SECTION 4.55(1A) MODIFICATION APPLICATION – SSD 11564741 STAGE 1B (STAGE 5) SUBDIVISION, BARANGAROO SOUTH

This modification application has been prepared by Ethos Urban on behalf of Lendlease (Millers Point) Pty Ltd (Lendlease), pursuant to section 4.55(1A) of the *Environmental Planning and Assessment Act 1979* (EP&A Act) to modify Development Consent SSD 11564741 relating to the stratum subdivision of Stage 1B (Stage 5) at Barangaroo South (the site).

BASEMENT LEVEL 3

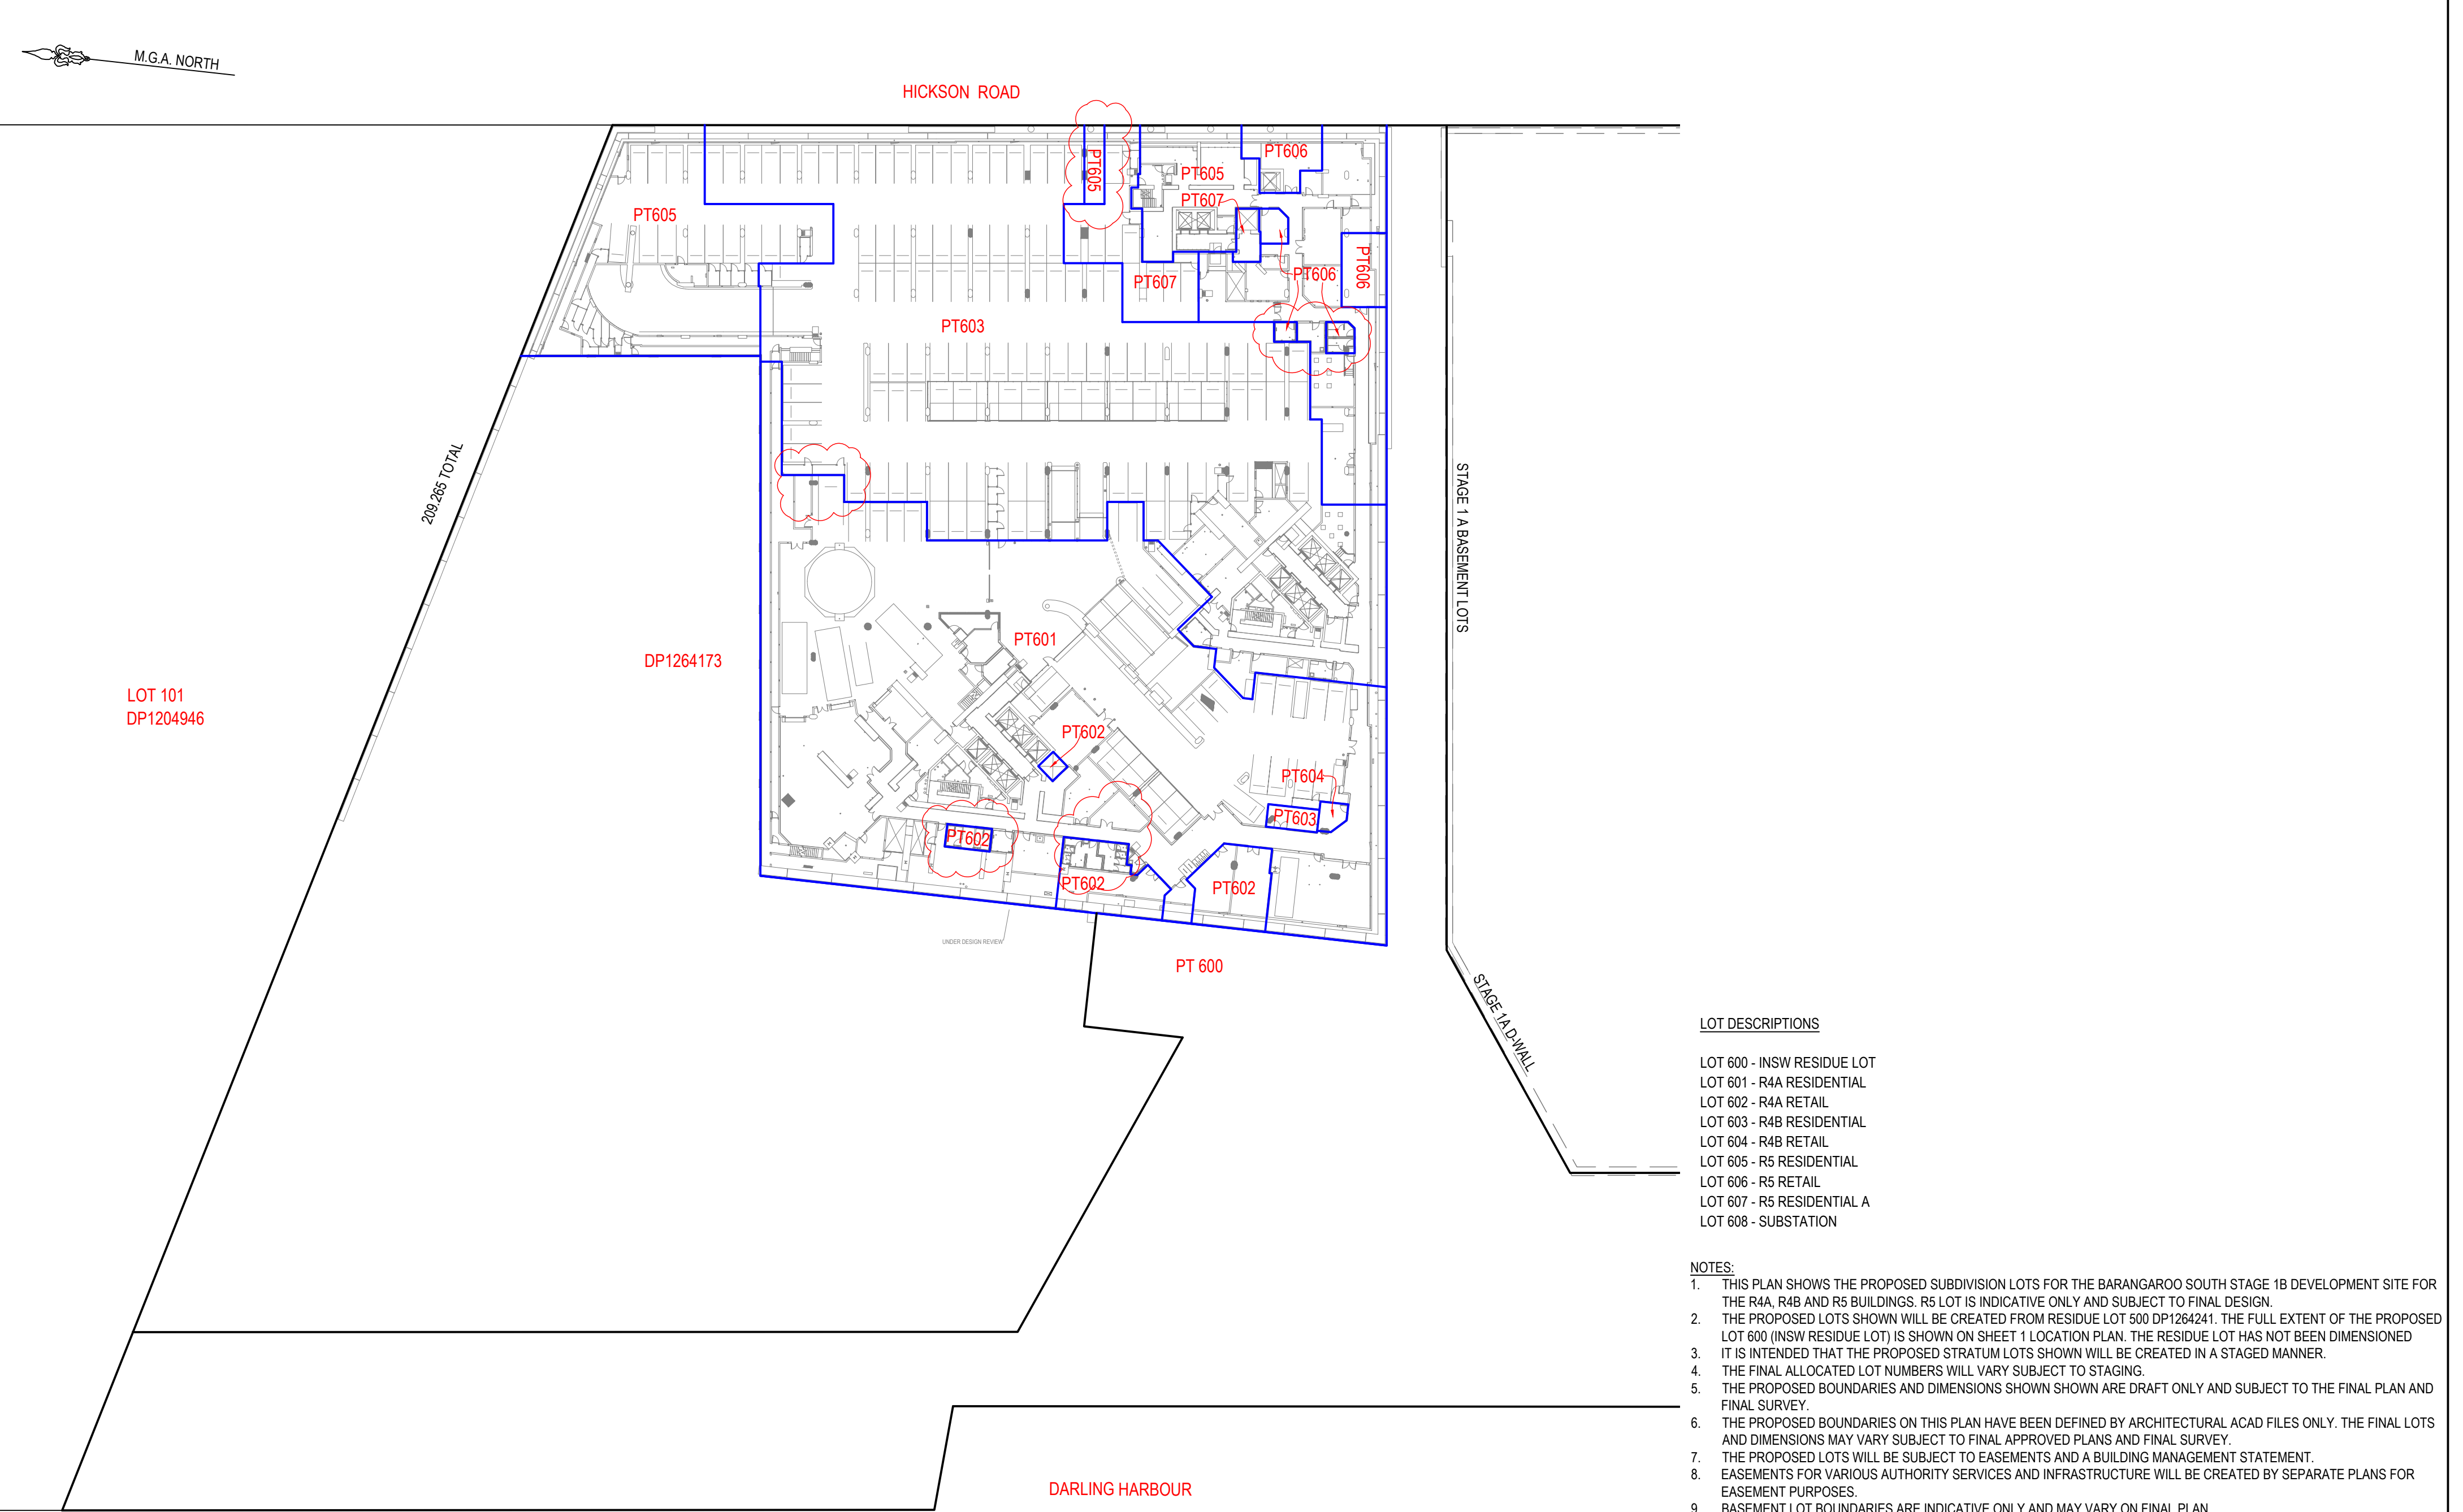
To reflect the proposed changes on Basement Level B3 with respect to parking (sought under separate modification applications to Building R4B).

- Amendment of the Stratum lot boundaries between Lots 601 and 603 to reflect the proposed changes on Basement Level B3 (parking sought under separate modification applications to Building R4B).
